City of Albuquerque

**RE: Grading and Drainage Plan For El Camino Medical Office (J19-D22) Dated
September 27, 2001**

**RE: Grading and Drainage Plan For El Camino Medical Office (J19-D22) Dated
September 12, 2001**

SHEET NO.
GP-1

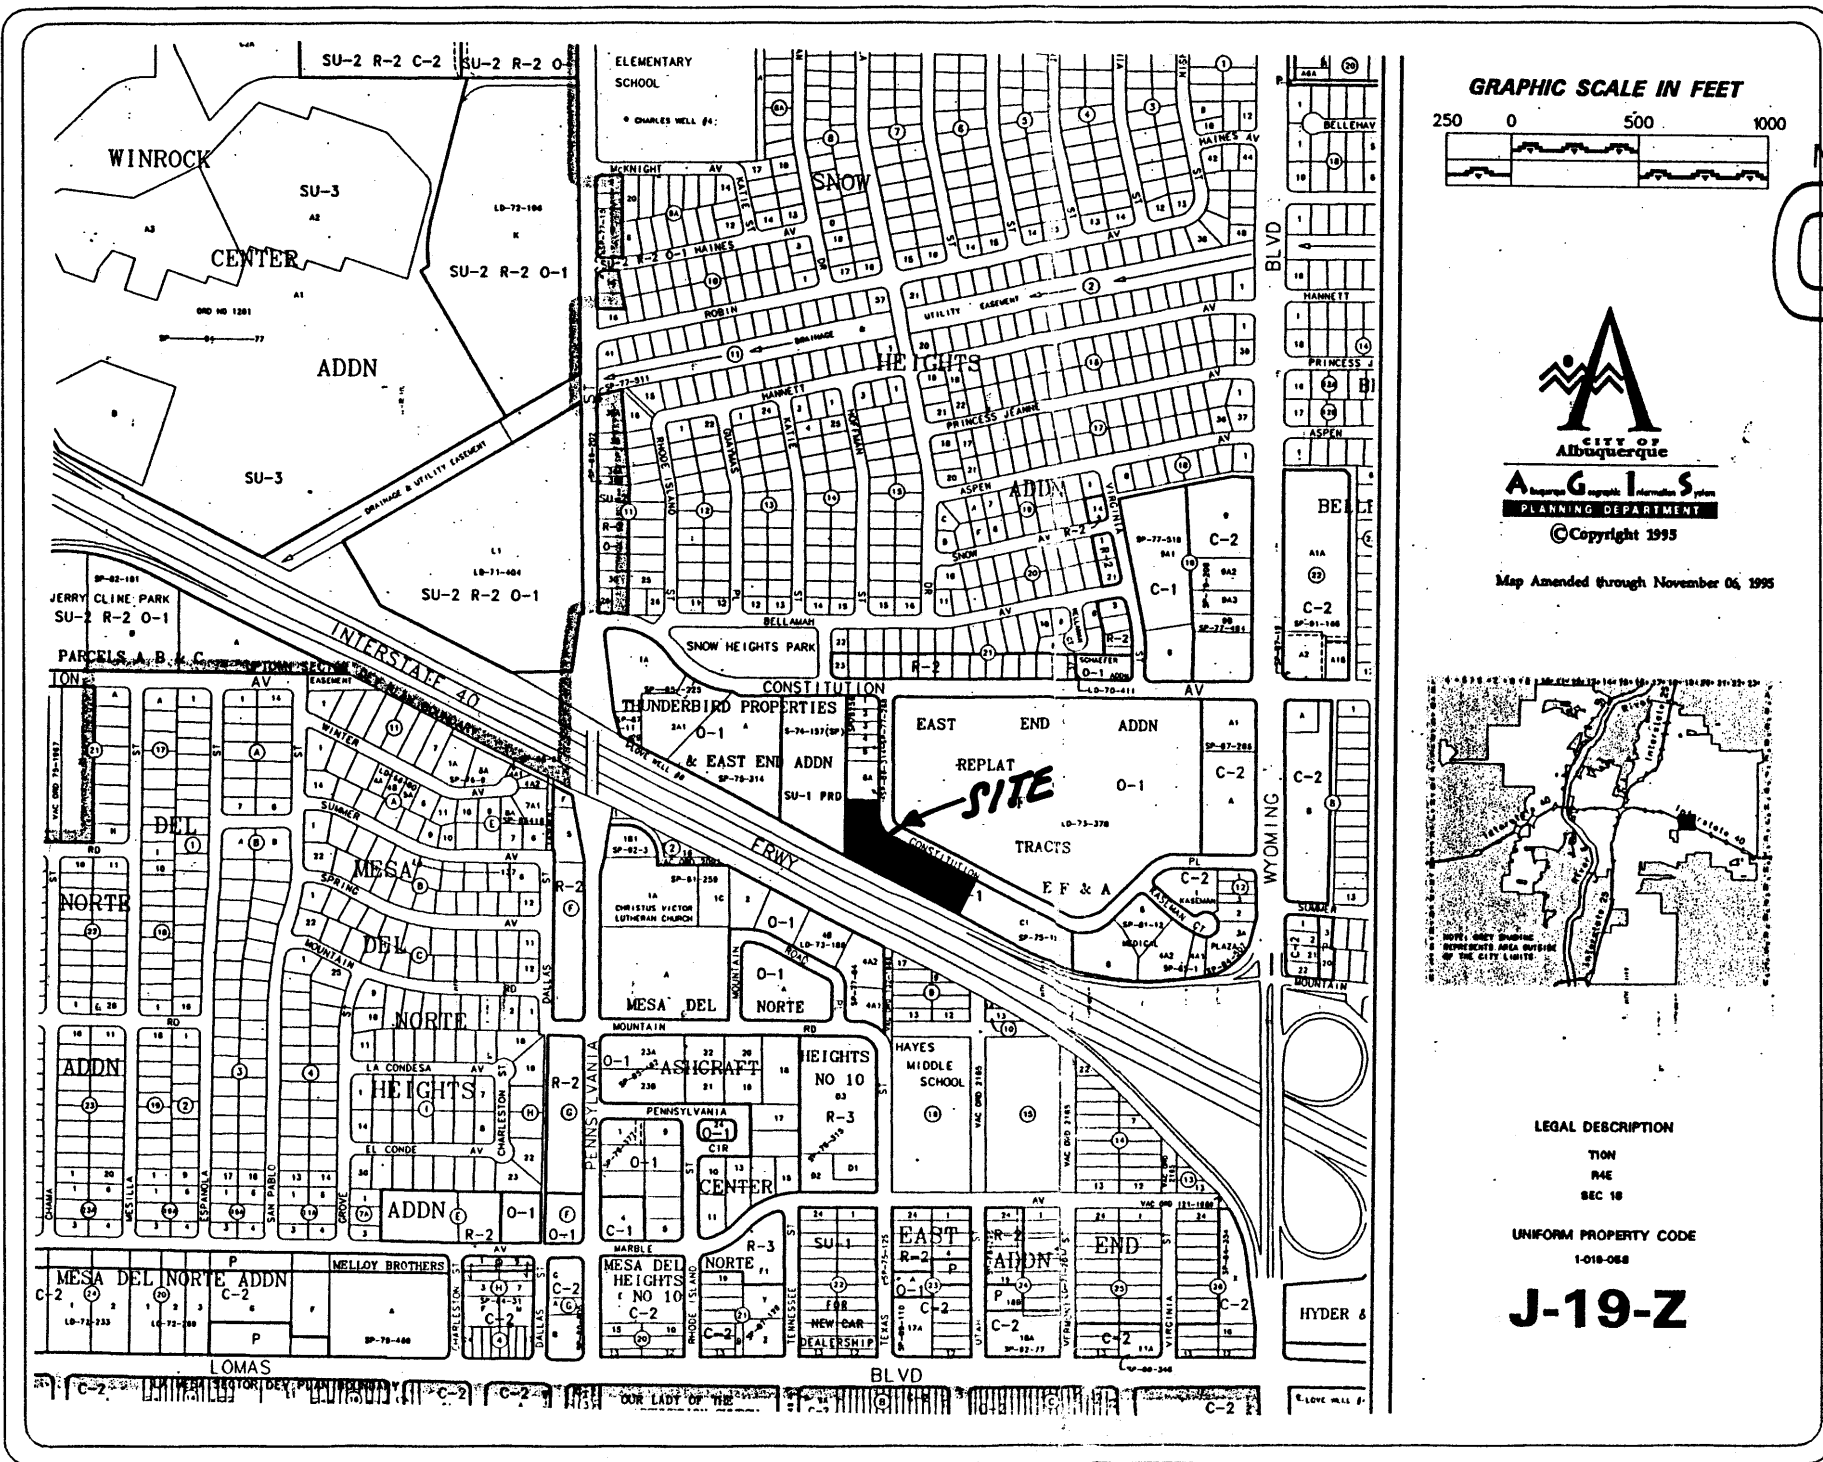
1. Please address if there is any offsite flows into the site. If there is offsite flow please quantify them.
2. Please obtain permission from the Highway Department. If they indicate that you do not need a permit please have them indicate this to me.
3. Please indicate if there is a one foot water block on the drive pads.
